## MEMORANDUM

DATE: January 24, 2019

FROM: Jeff Rice, PCD-Engineering

SUBJECT: SKP-18-006 – The Ranch  
First Submittal

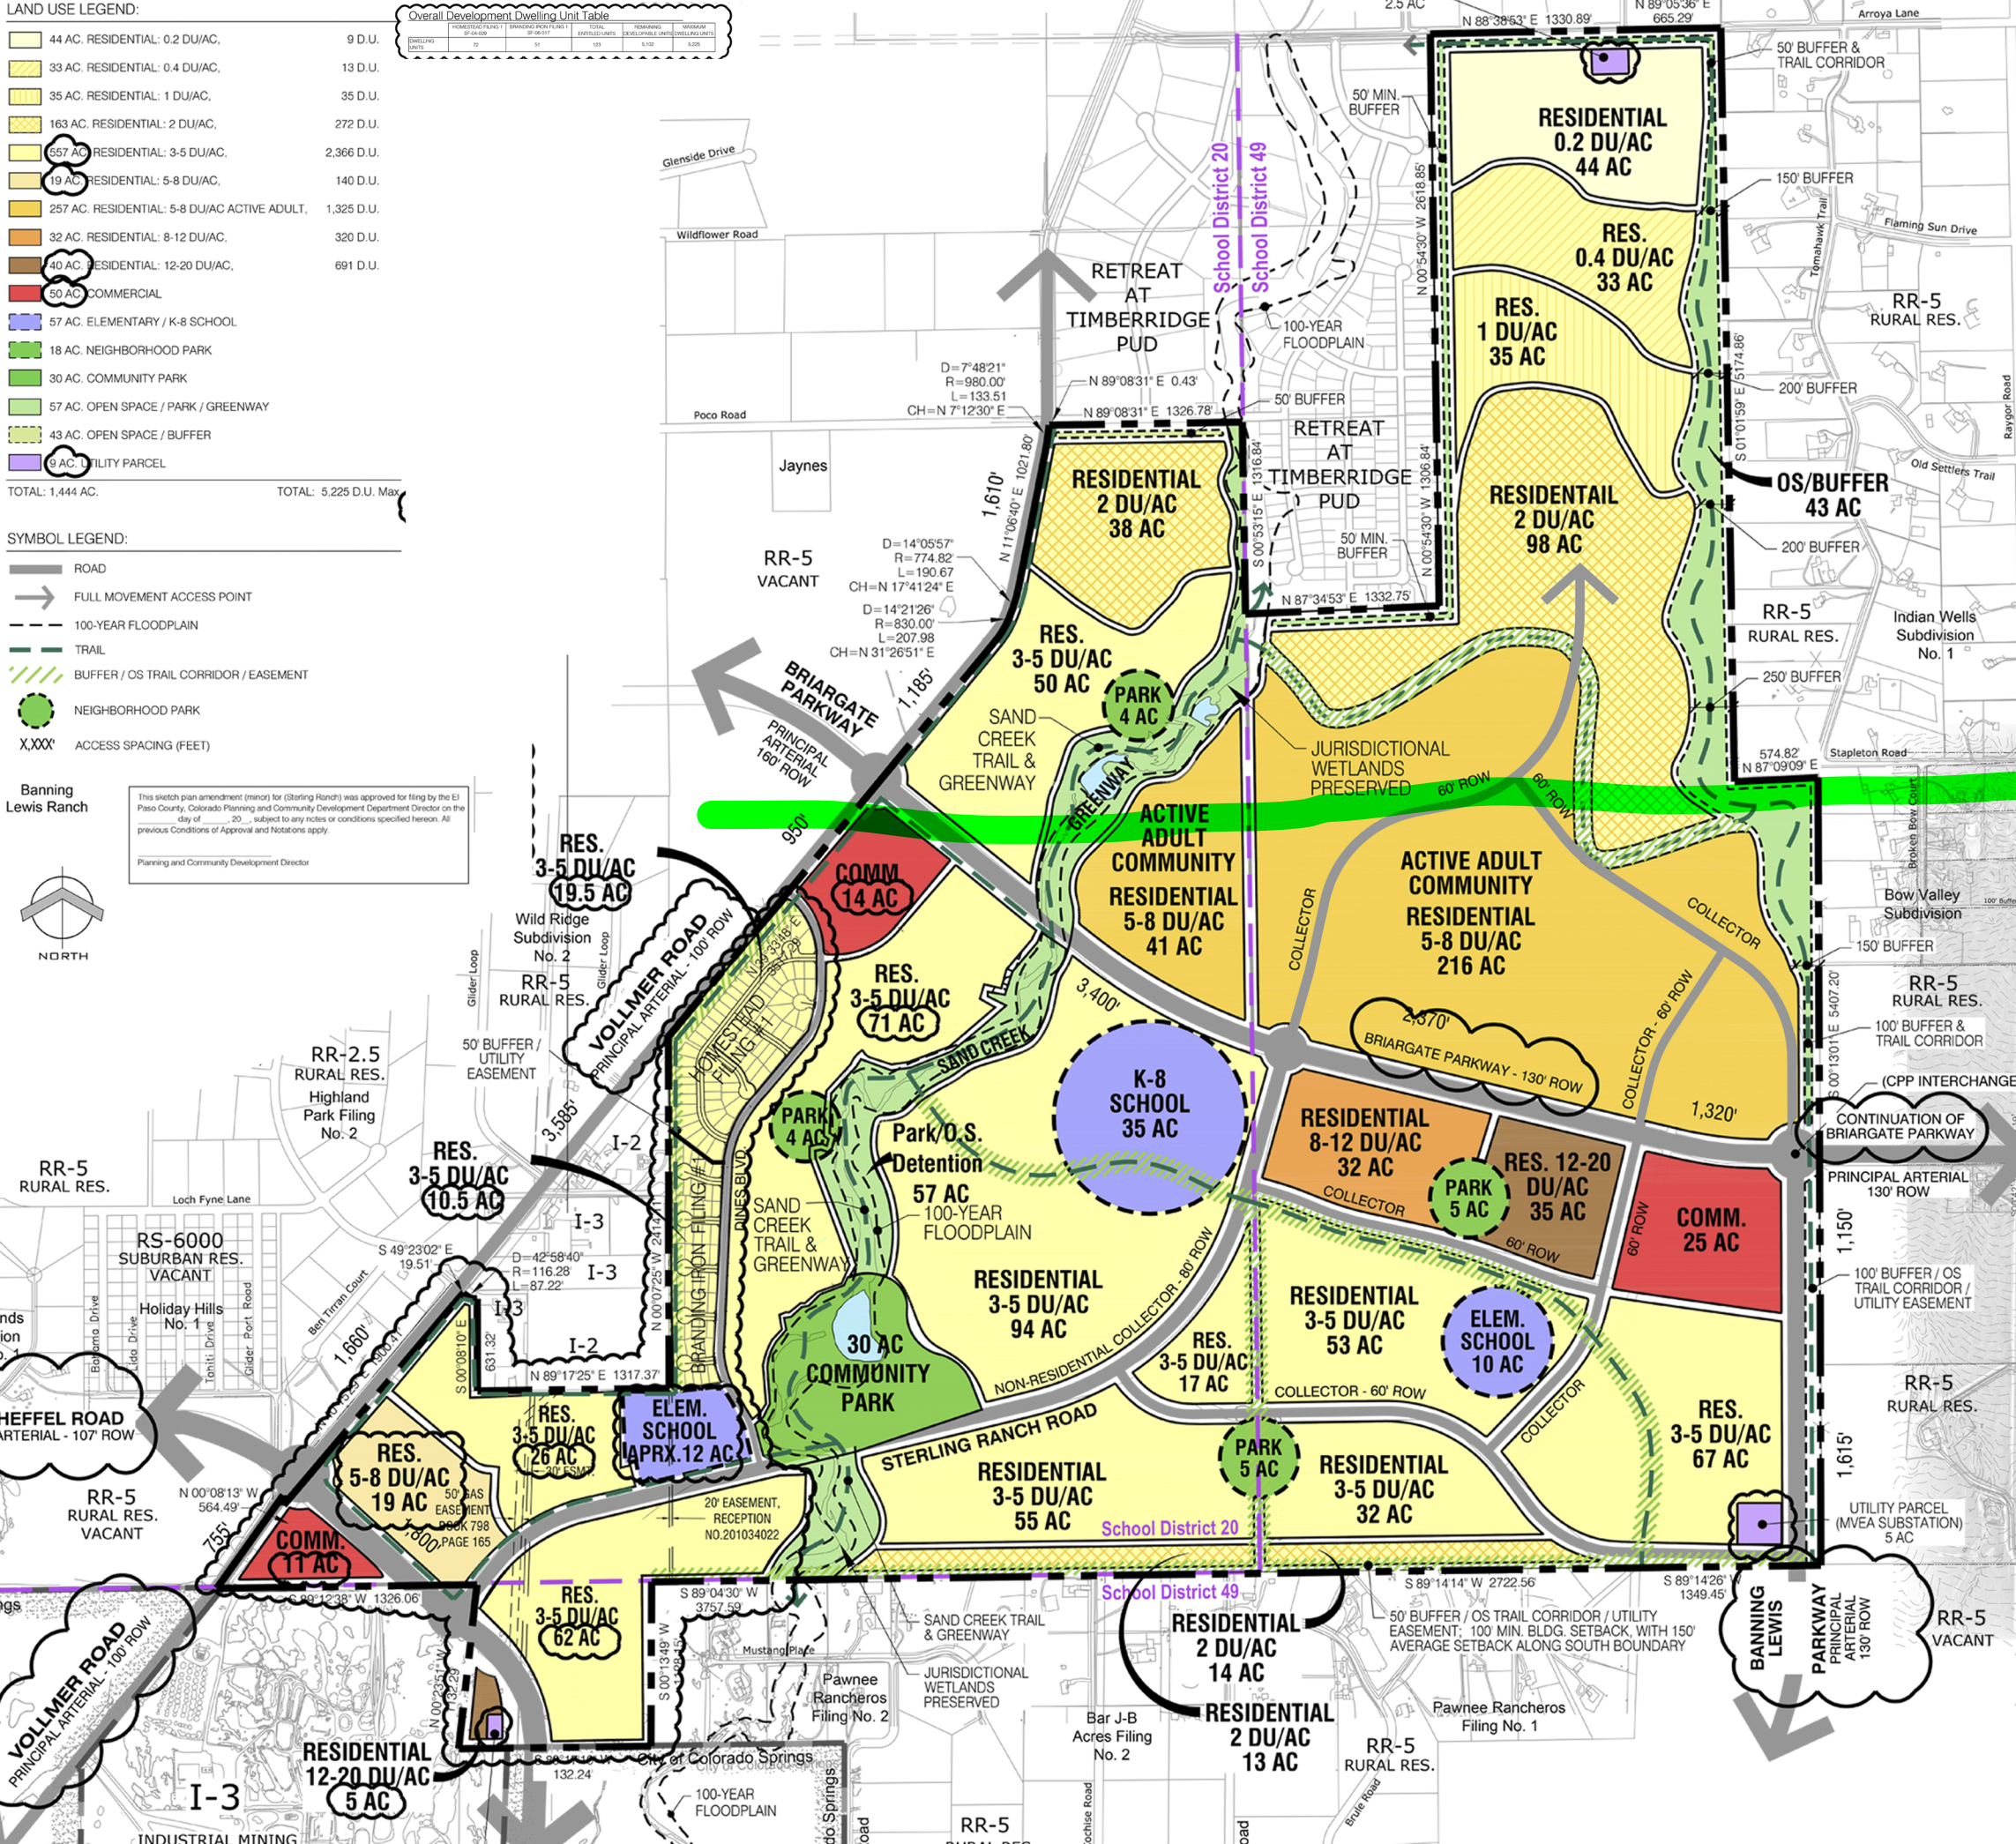
1. See Sketch Plan redlines.  
**RESPONSE: addressed.**
2. Label roads as existing/proposed.  
**RESPONSE: Addressed**
3. Provide the proposed conceptual Stapleton/Briargate cross-section for the proposed 150-foot right-of-way. If the right-of-way is non-standard, a deviation request is required at the Preliminary Plan stage (or before).  
**RESPONSE: Added based on standard 4-lane principal arterial cross-section with wider median at variable width.**
4. Regarding Briargate/Stapleton naming, until a decision has been made approving the street name, label the proposed road as both, "Stapleton/Briargate".  
**RESPONSE: Amended on plan and in LOI.**
